RE: TCL Response | Blake's Lotaburger #45 (J10-D052)

Thank you for the review comments on the TCL for the Blake's Lotaburger proposed at 641 Coors Boulevard. See responses below and relevant drawings attached. Items are numbered based on the Review numbers:

BLAKE'S LOTABURGER #45
641 COORS BLVD. NW
ALBUQUERQUE, NM 87121
OFFSITE IMPROVEMENTS

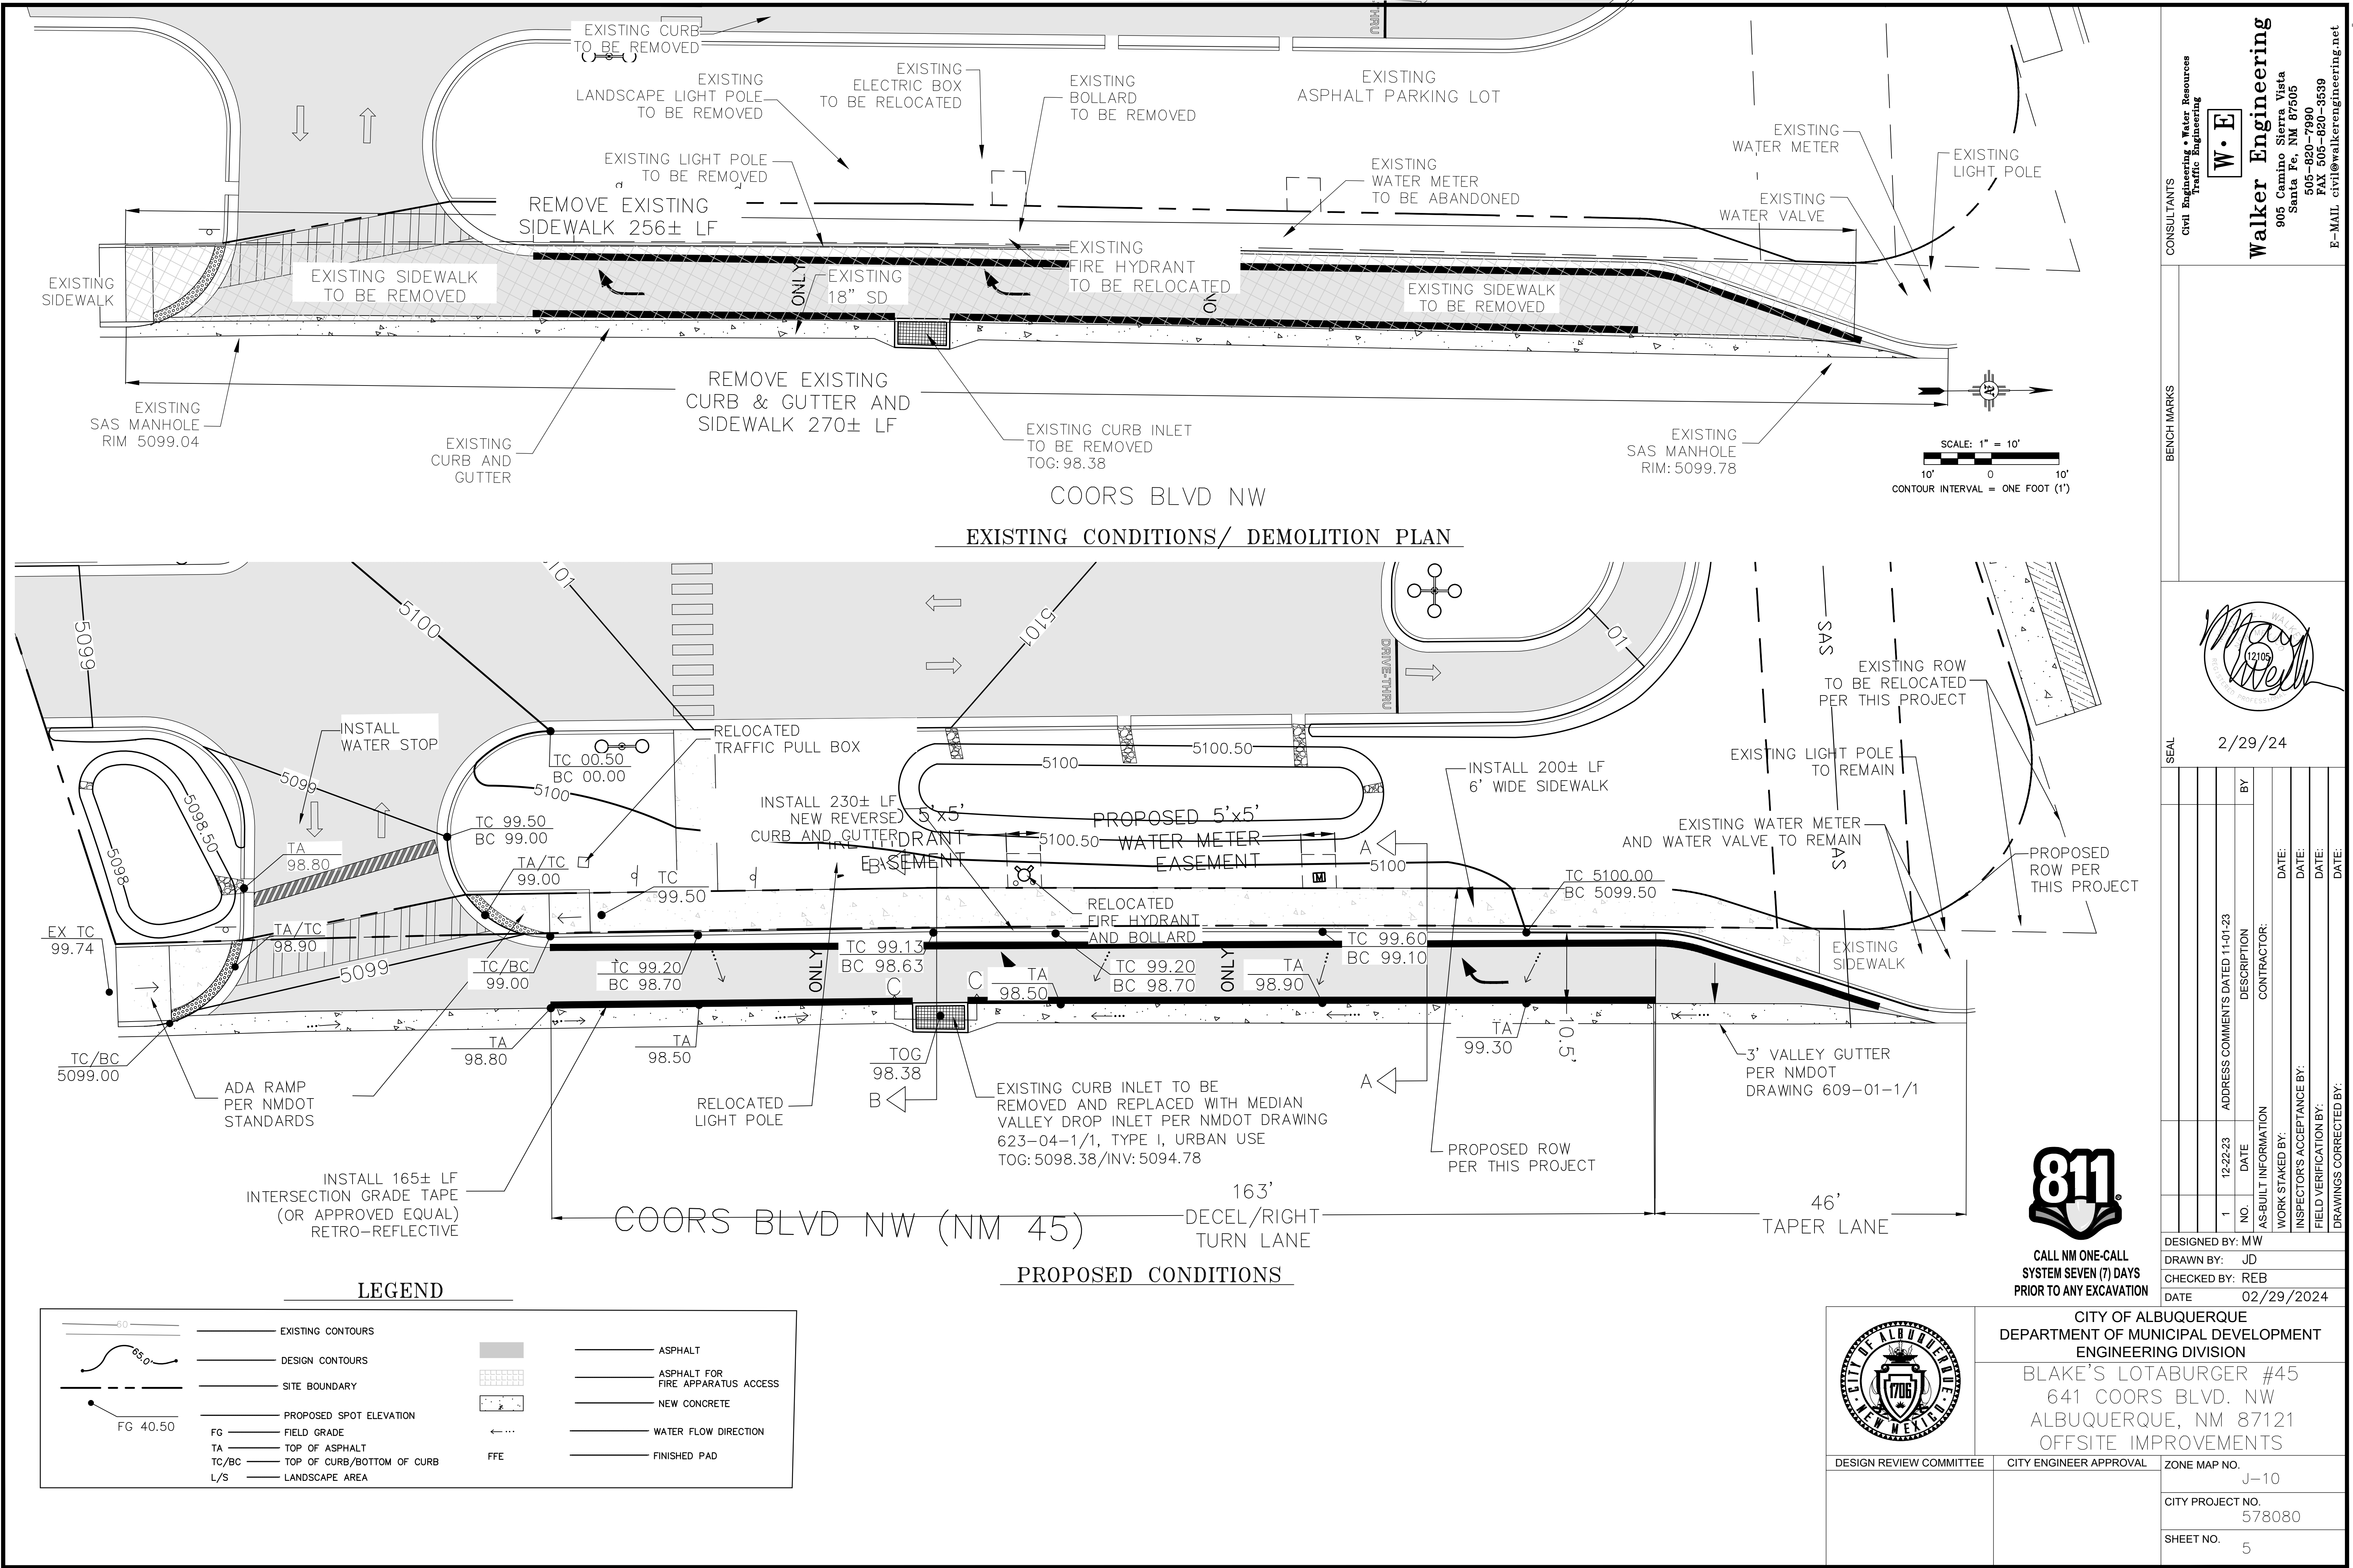
4. See Civil drawing, C3 attached for site access ramps and details.
5. See attached revised TCL for added lettering.
6. See attached revised TCL for additional dimensions.
